**OXFORDSHIRE COUNTY COUNCIL'S RESPONSE TO CONSULTATION ON THE  
FOLLOWING DEVELOPMENT PROPOSAL**

**Application no:** 14/01054/REM

**Proposal:** Reserved Matters Application for construction of 113 dwellings (Parcel KM4)  
pursuant to Condition 35 of 06/00967/OUT

**Location:** KM4 South West Bicester Development Site Middleton Stoney Road Bicester  
Oxfordshire

TYPICAL SECTION SURFACE WATER OUTFALL FROM HOUSE DRAINAGE

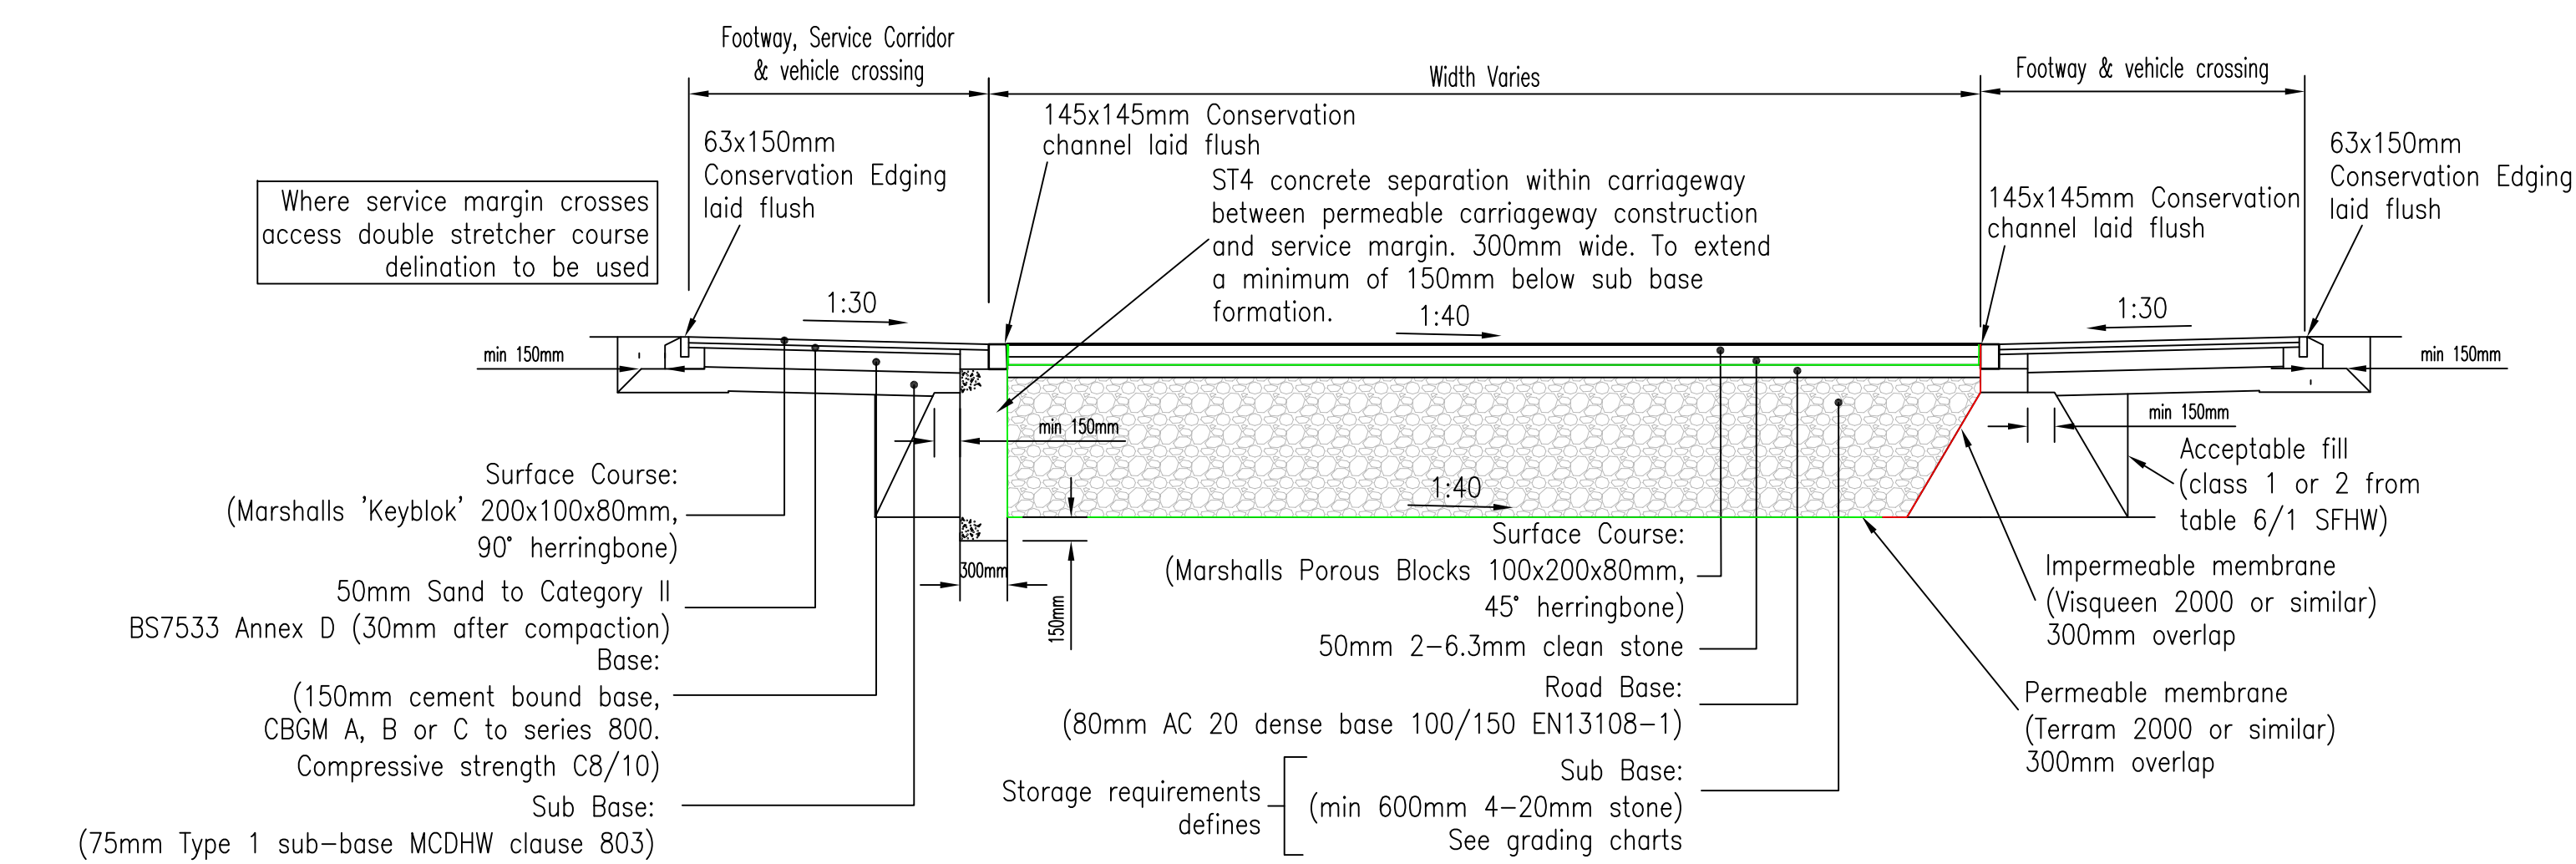
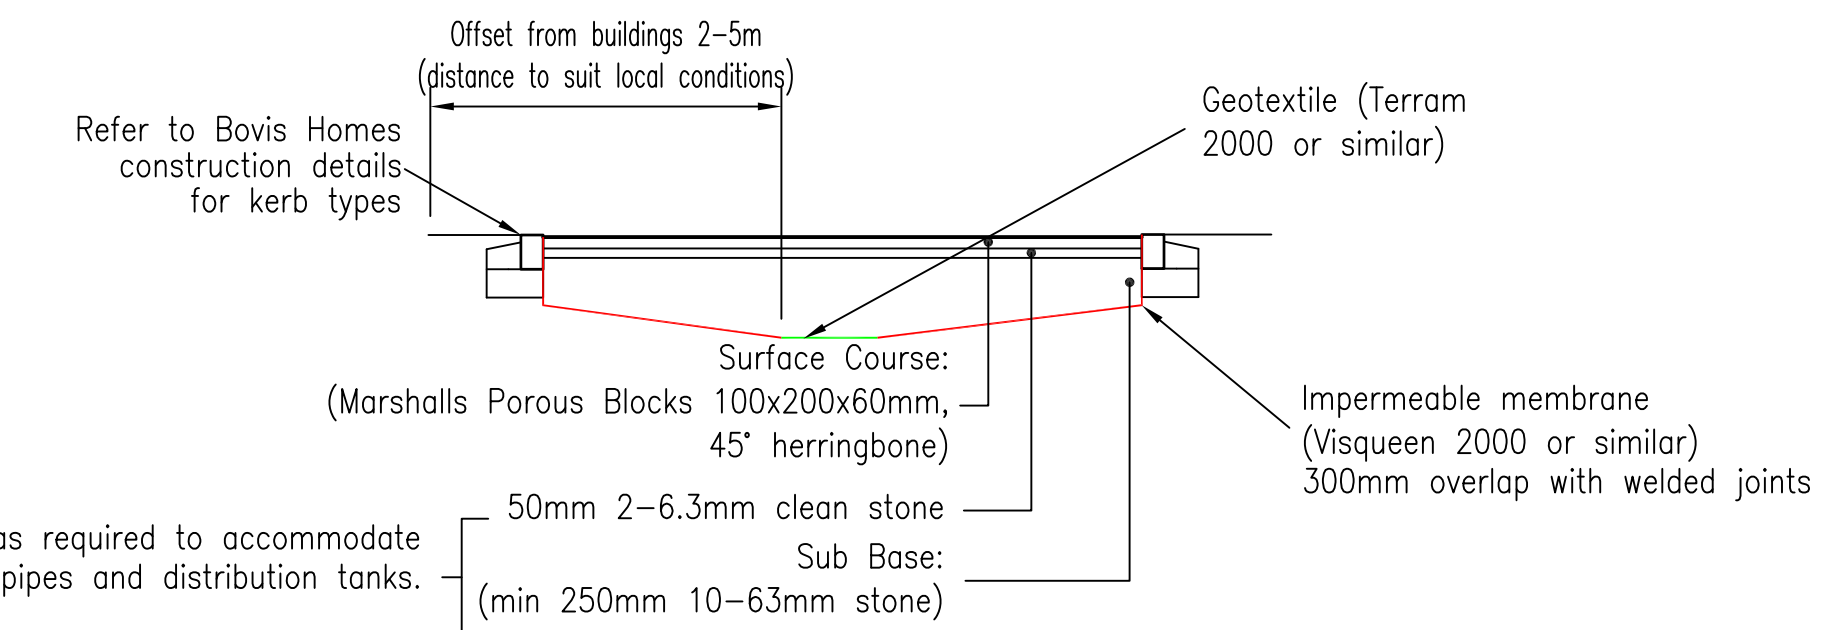
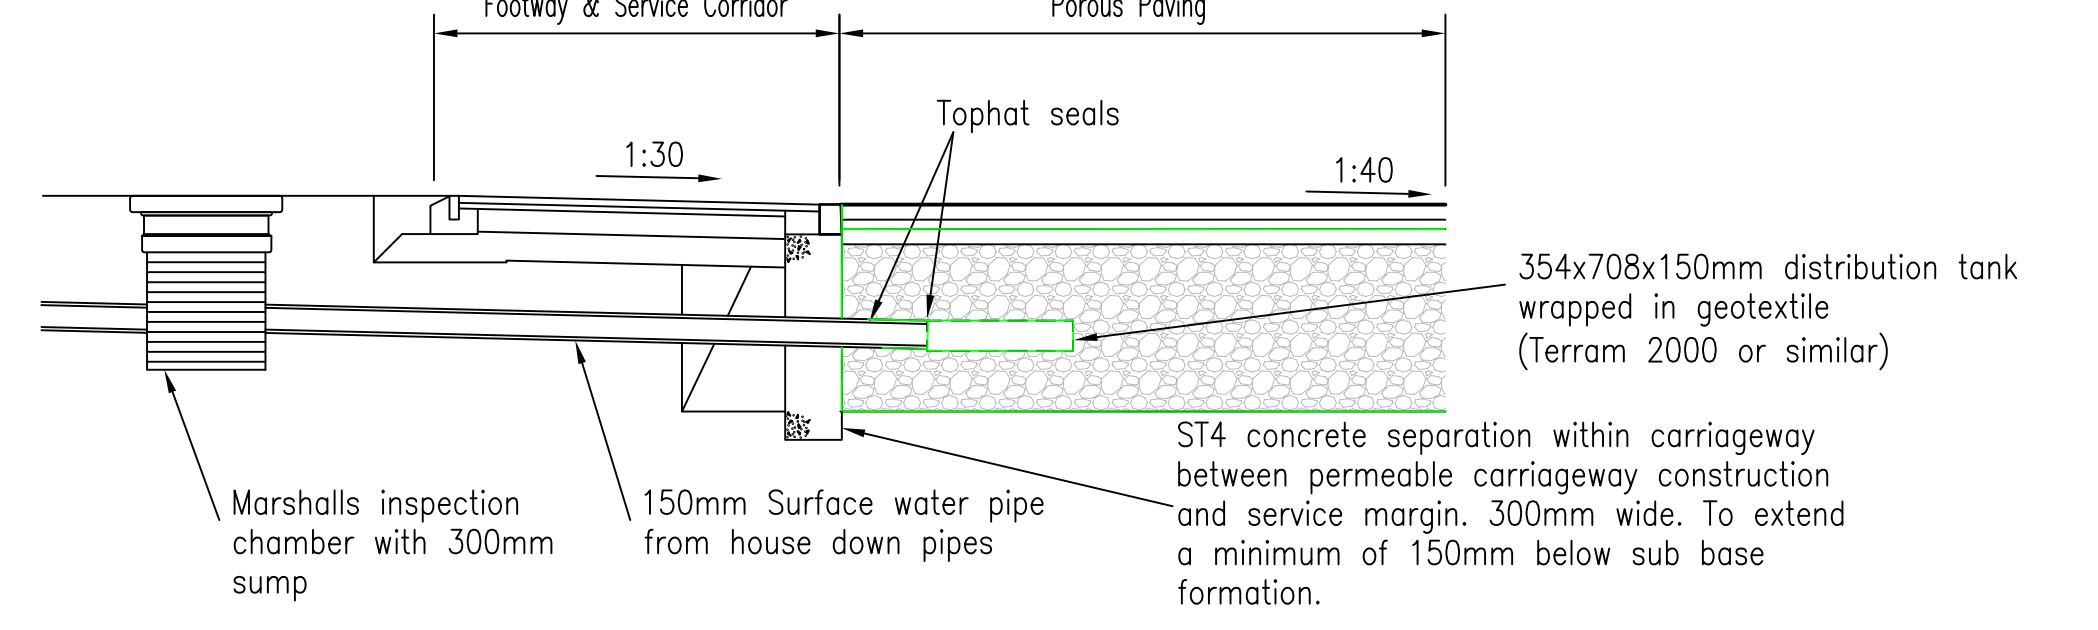
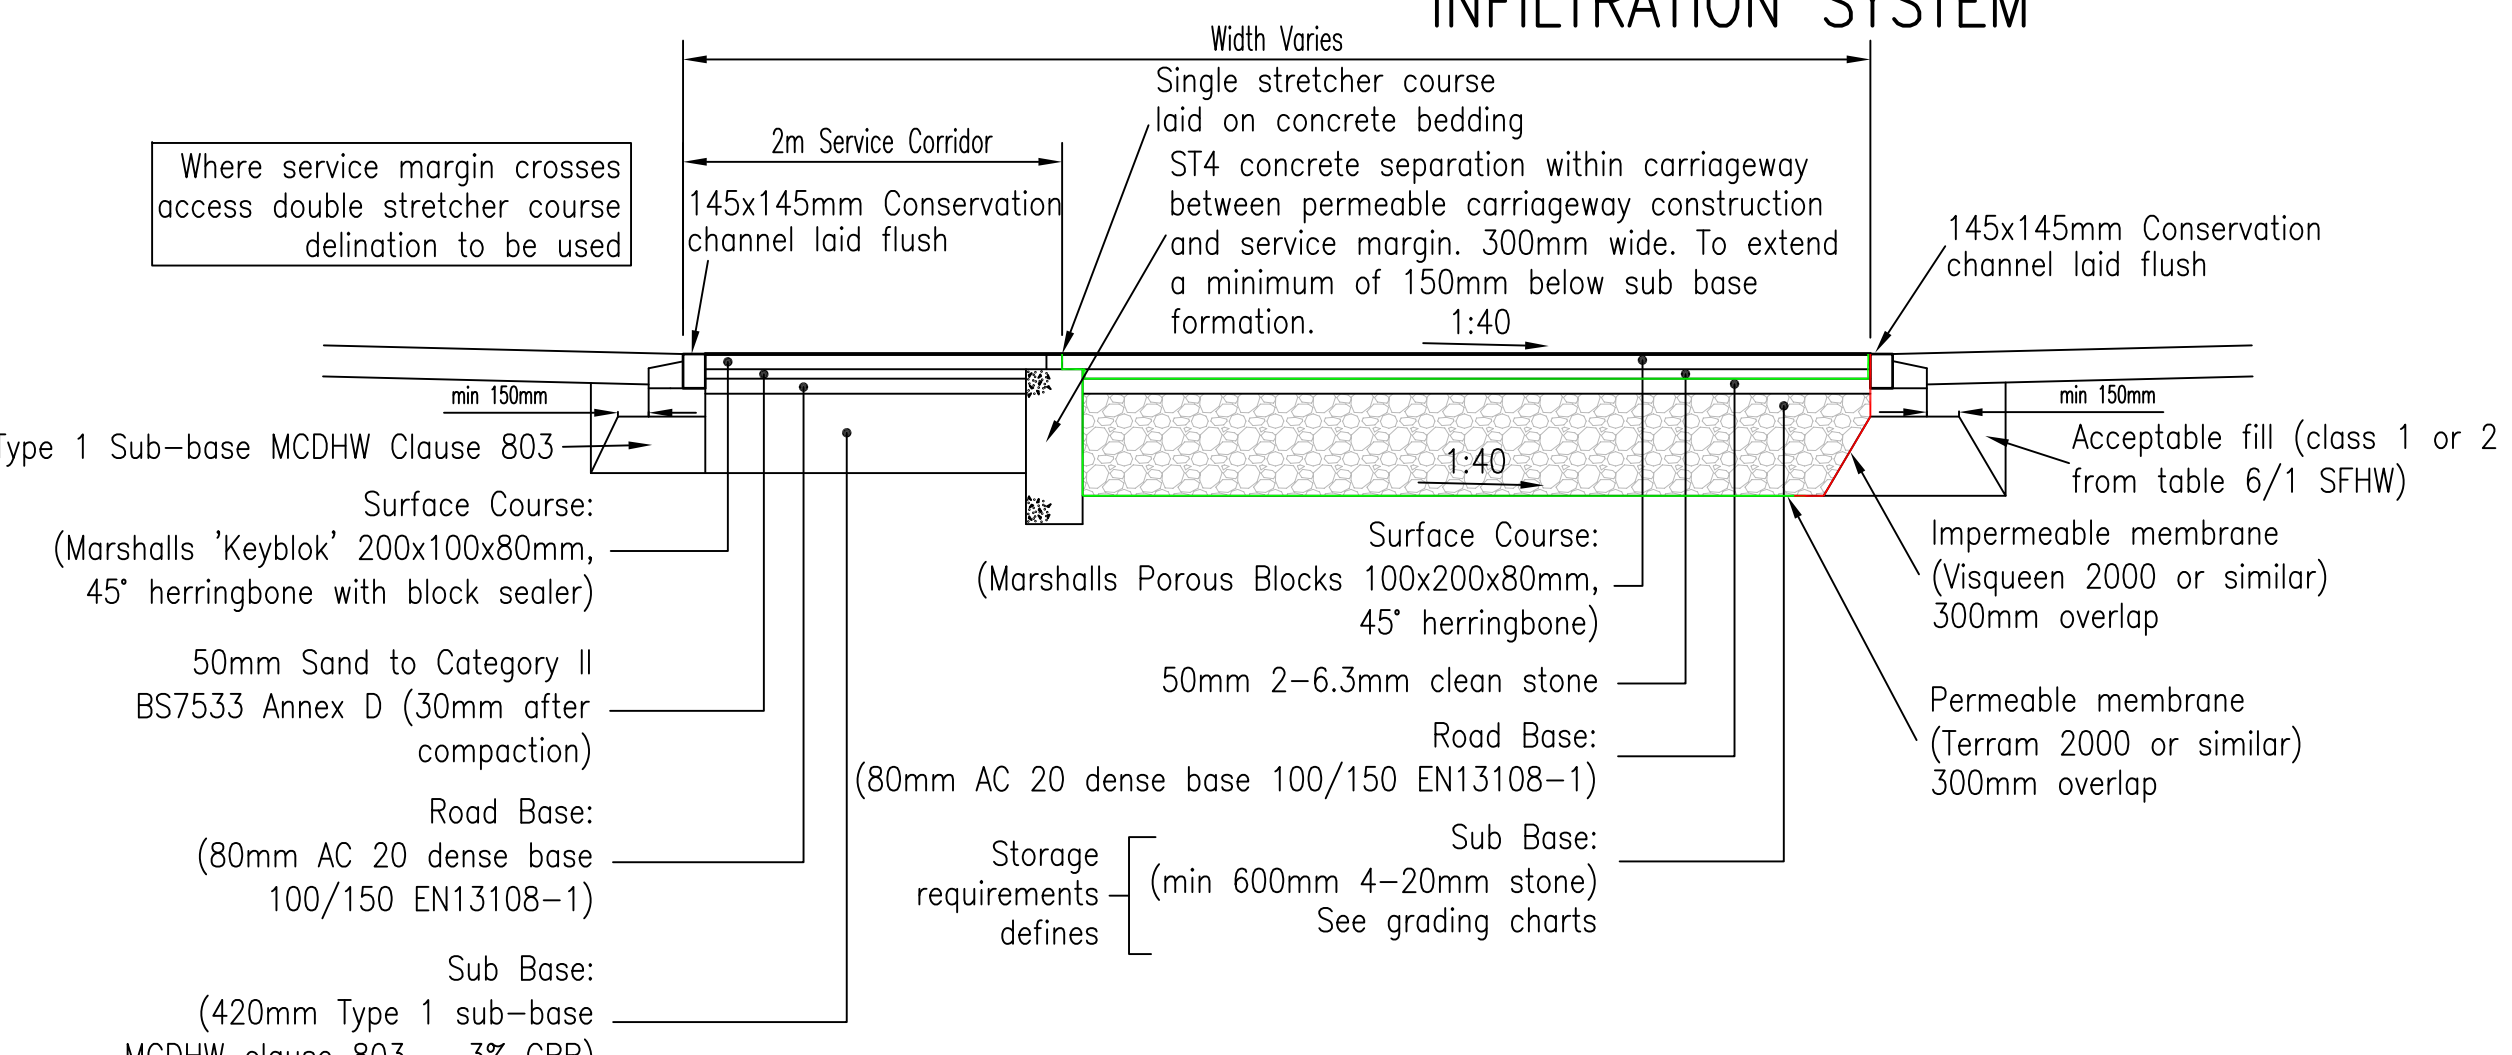
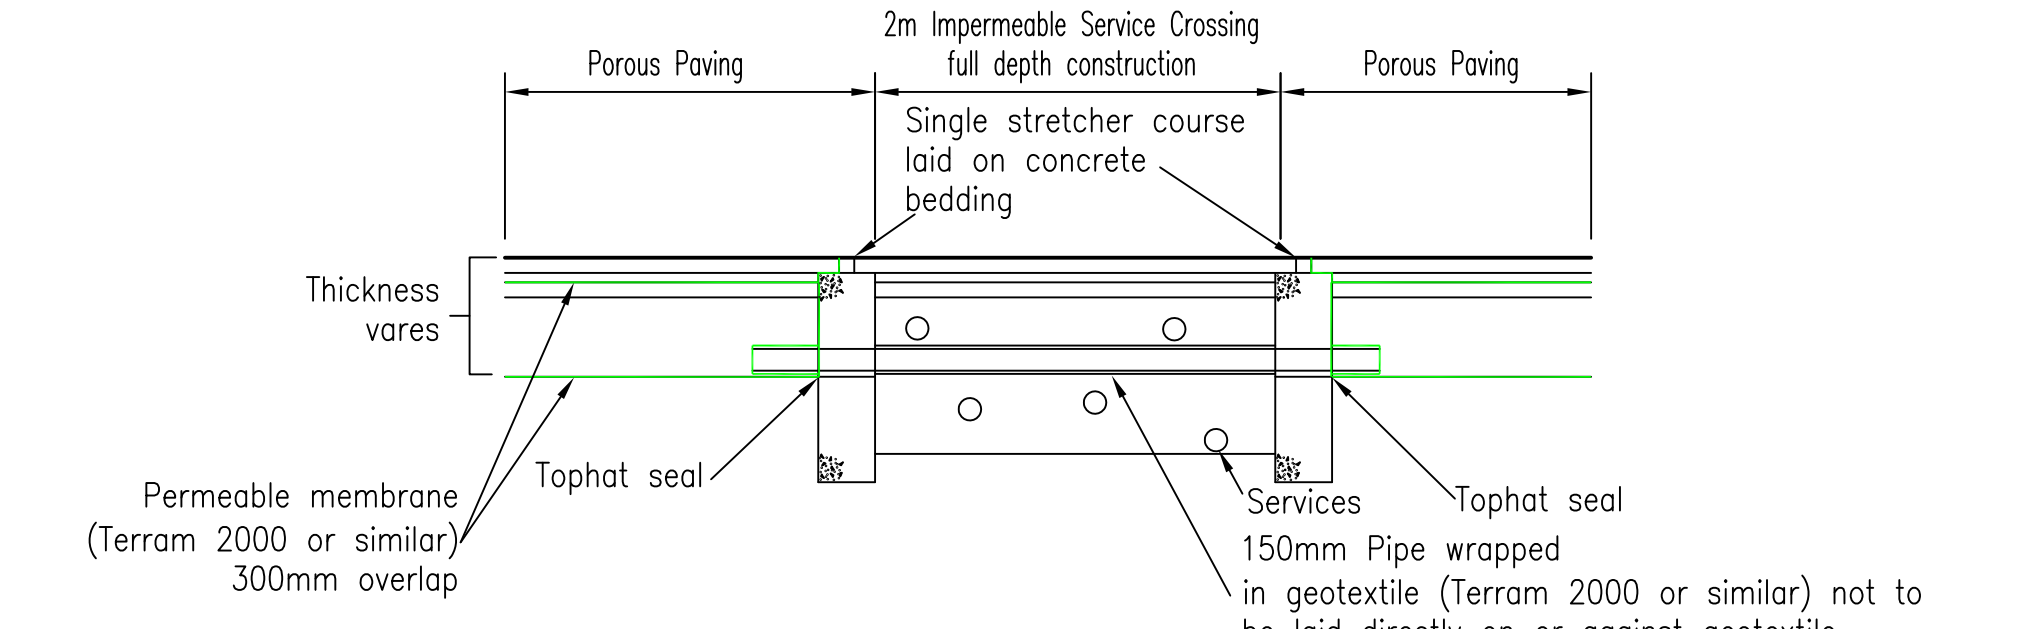
*Drawing number 10109-HL-012 shows a detail for private surface water connections into permeable paving. If it is proposed to drain private water into ‘adoptable’ permeable paving, the S38 agreement must be completed before any house sales. Minor amendments will also be required to some of the standard details/cross sections shown”.*
